PUBLIC PLANNING SUBMISSION: AMENDED DEVELOPMENT OBJECTION

Application: State Significant Development – 138 Maroubra Road (SSD-81426710)

Perspective: Surrounding Community Members & Adjoining Residential Neighbors

- PROFILE OF SHADOW CAST BY EXISTING BUILDING
- PROFILE OF ADDITIONAL SHADOW CAST BY PROPOSED DEVELOPMENT
- PROFILE OF SHADOW CAST BY SURROUNDING BUILDINGS

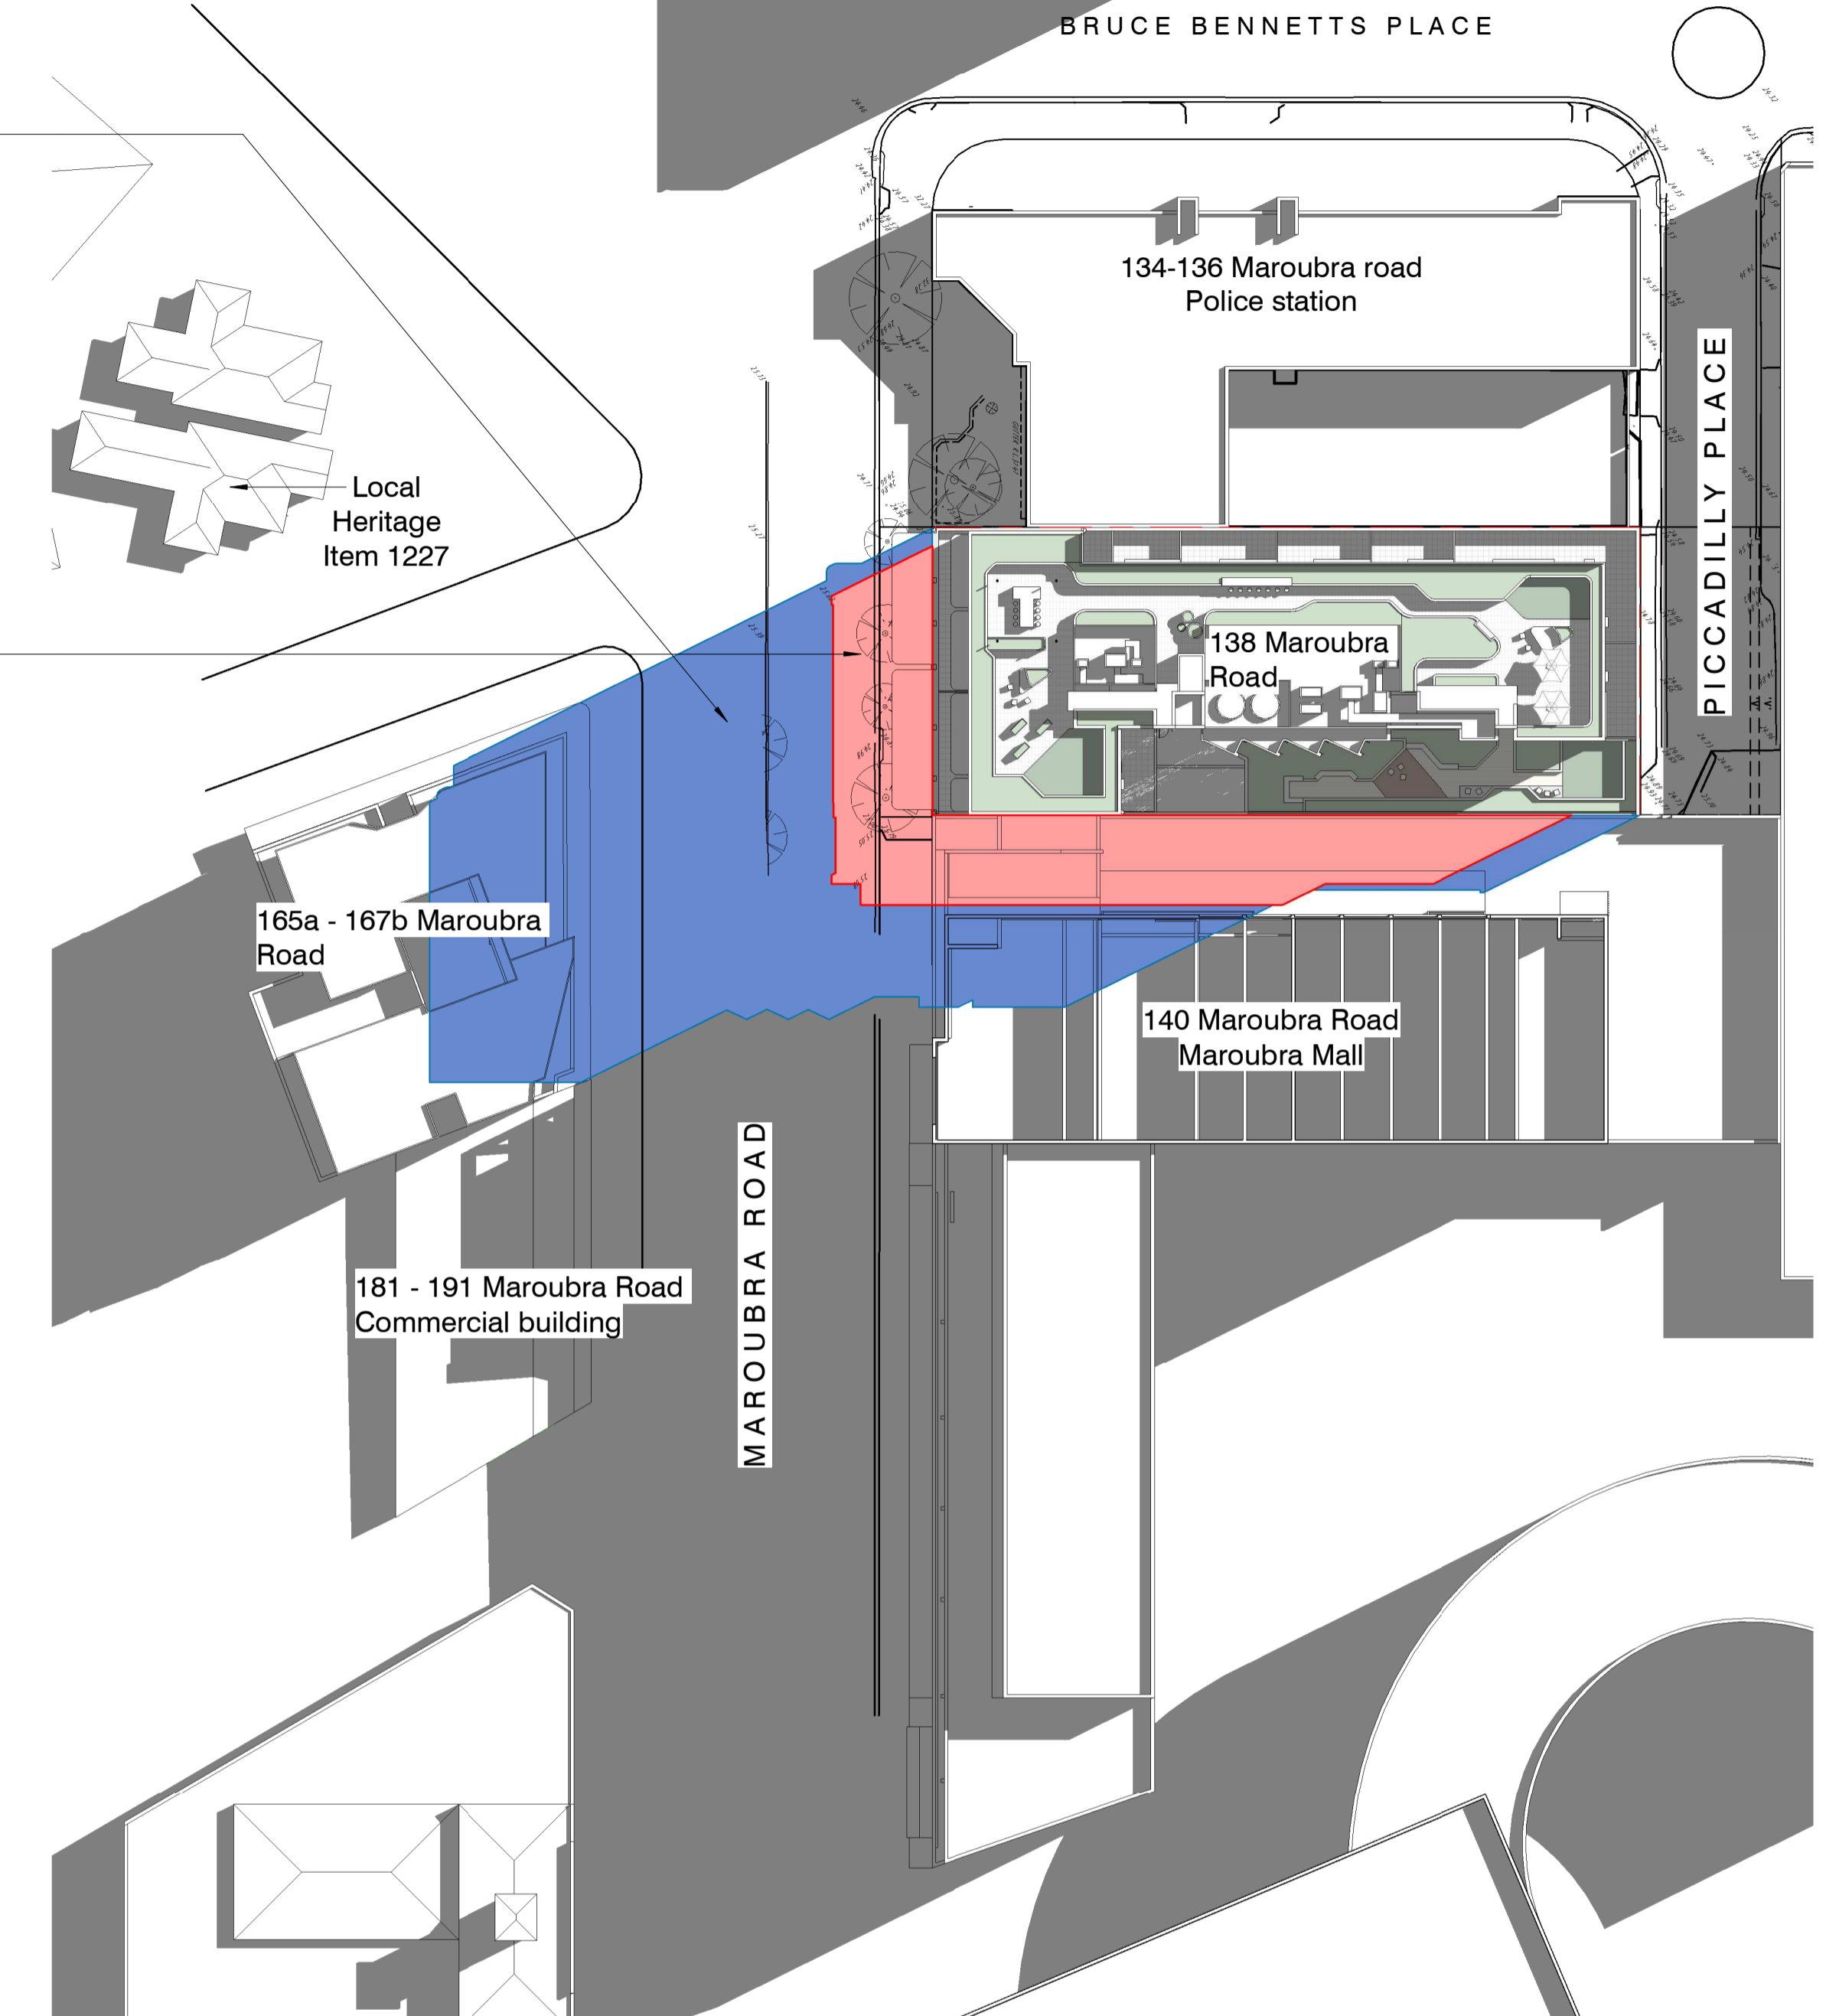
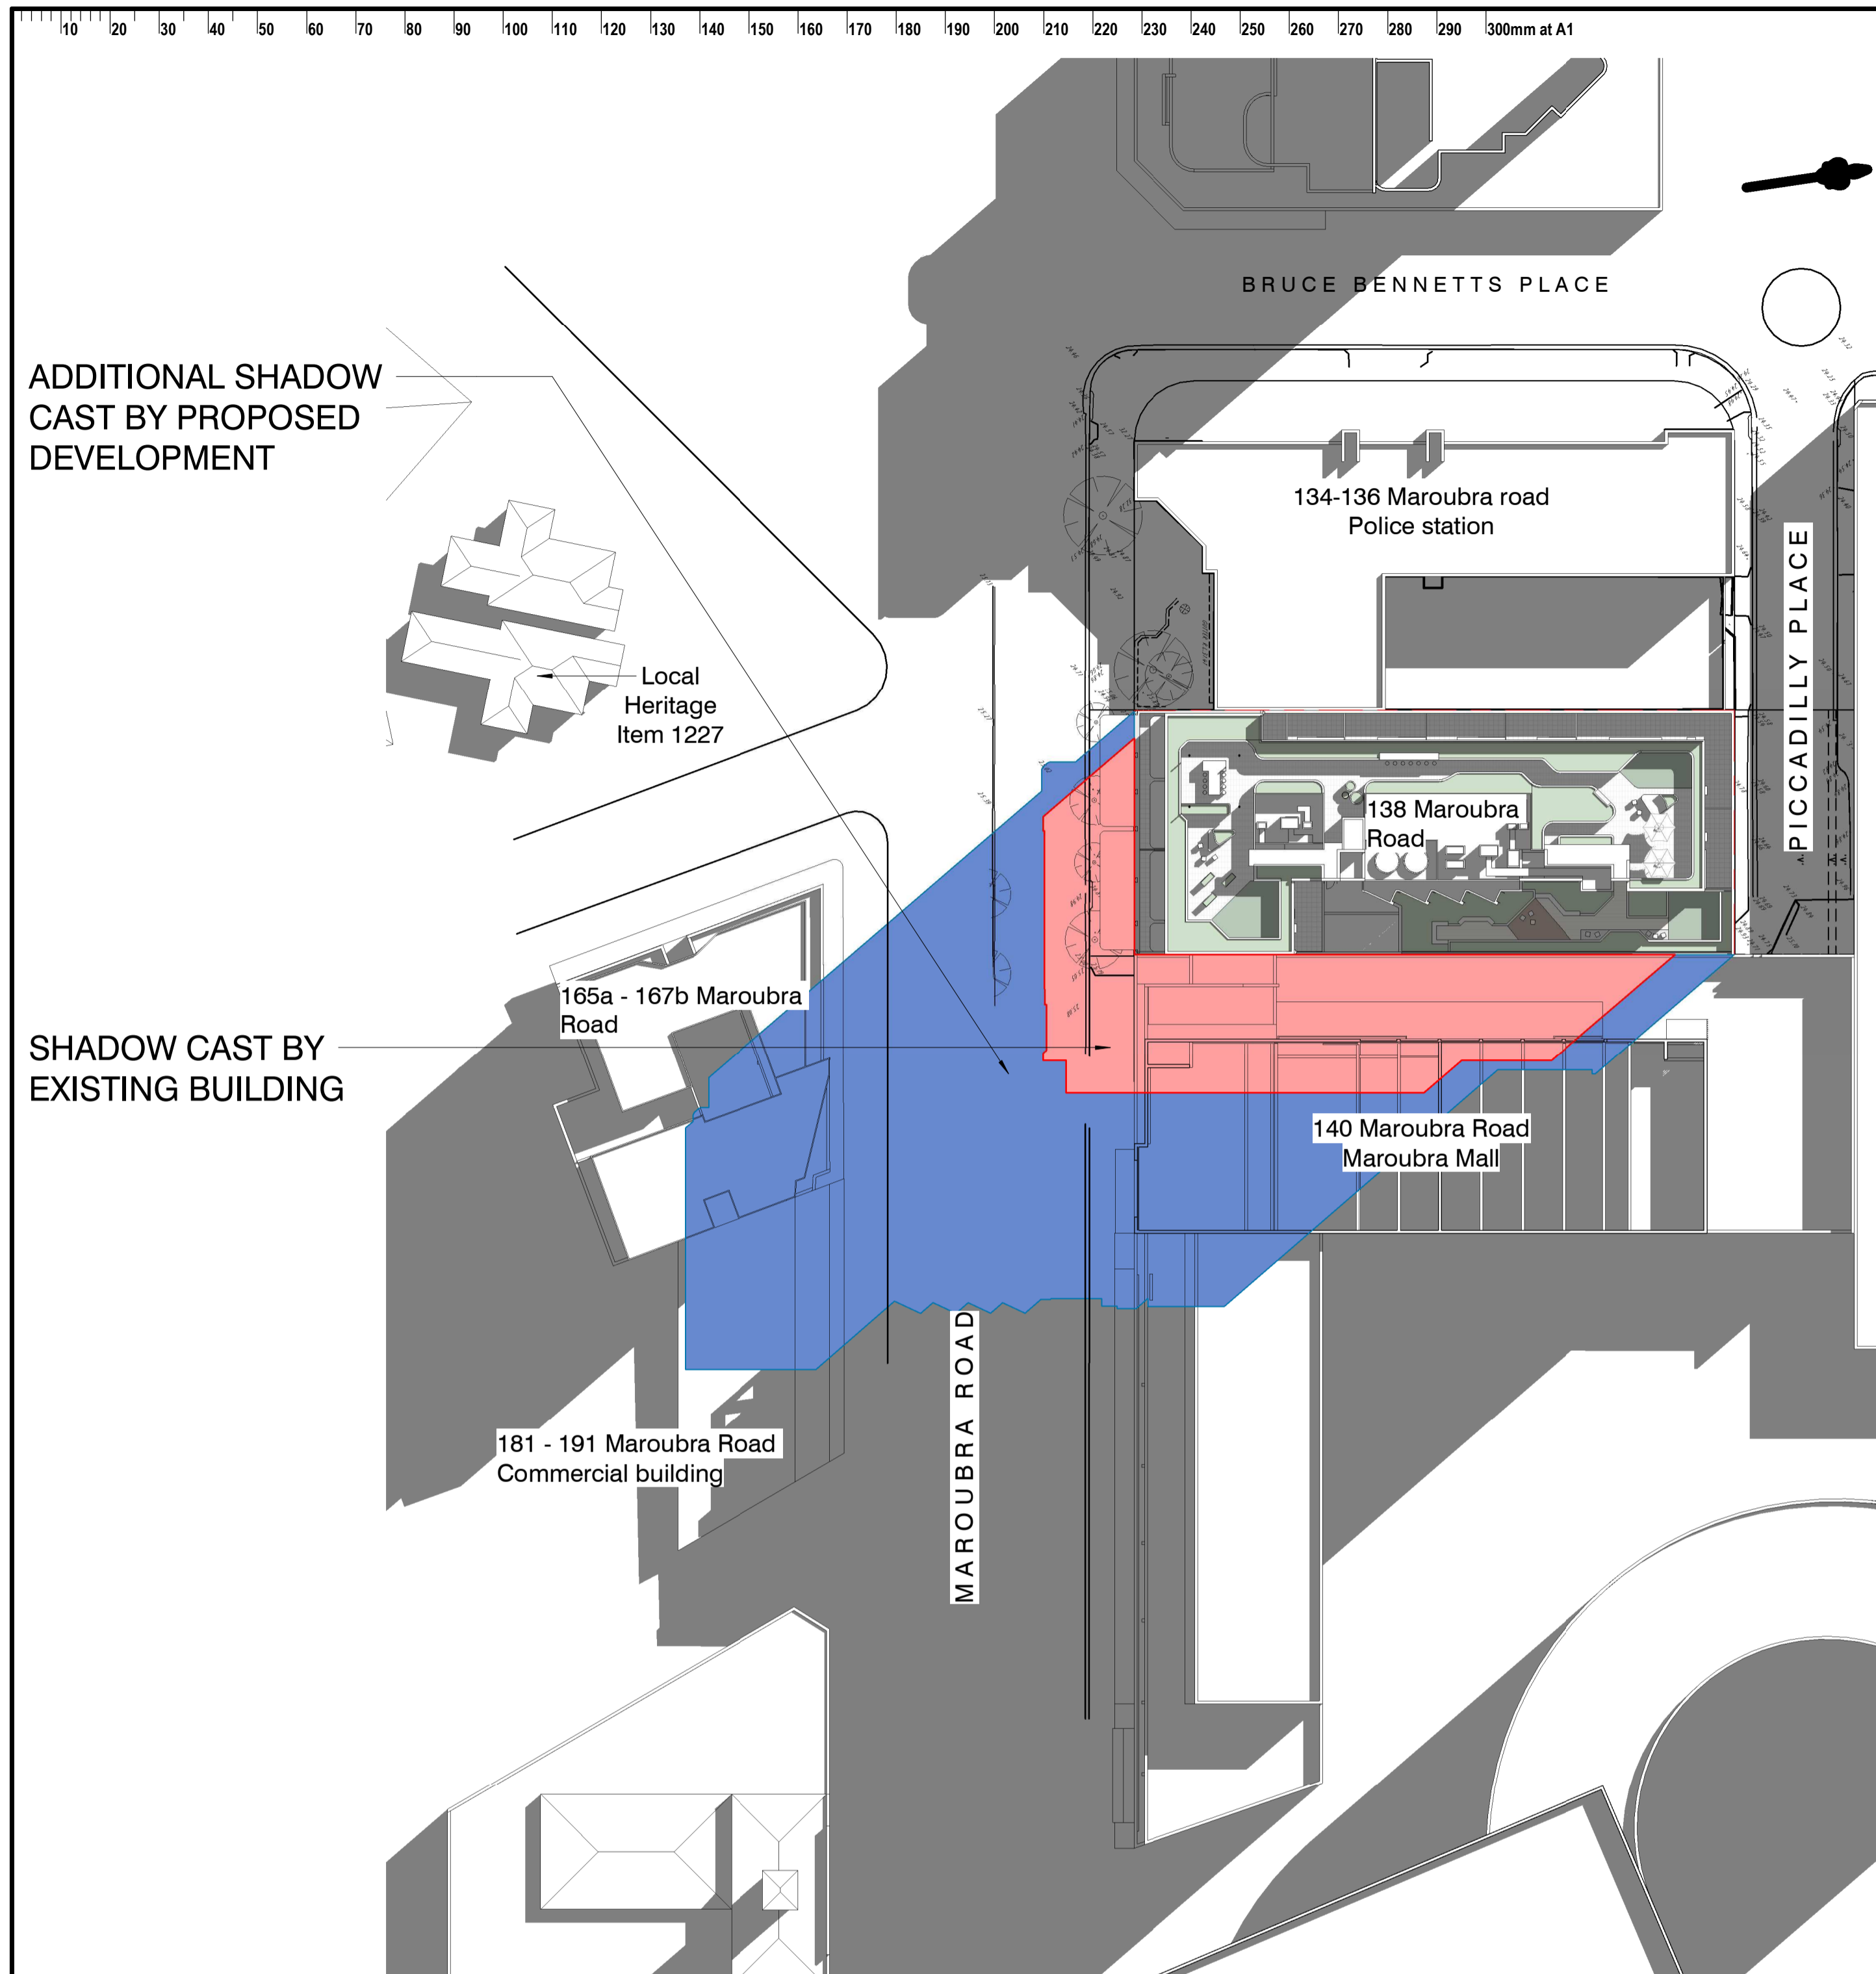
Afternoon Solar Deprivation and Extreme Microclimatic Shadowing on Adjoining Homes

The developer's updated shadow modeling relies on broad regional averages under the Apartment Design Guide (ADG), ignoring the direct microclimatic reality of neighboring properties. Constructing a deep, unarticulated 10-storey concrete envelope right to the boundary line completely blocks essential afternoon daylight.

Natural light is a crucial component of local living standards and natural apartment warmth. Depriving surrounding homes of afternoon sunlight degrades the well-being of neighboring residents. This impact is disproportionately borne by the high concentration of less-mobile senior citizens living in the adjacent building who stay indoors and depend heavily on natural sunlight for physical health and daily warmth.
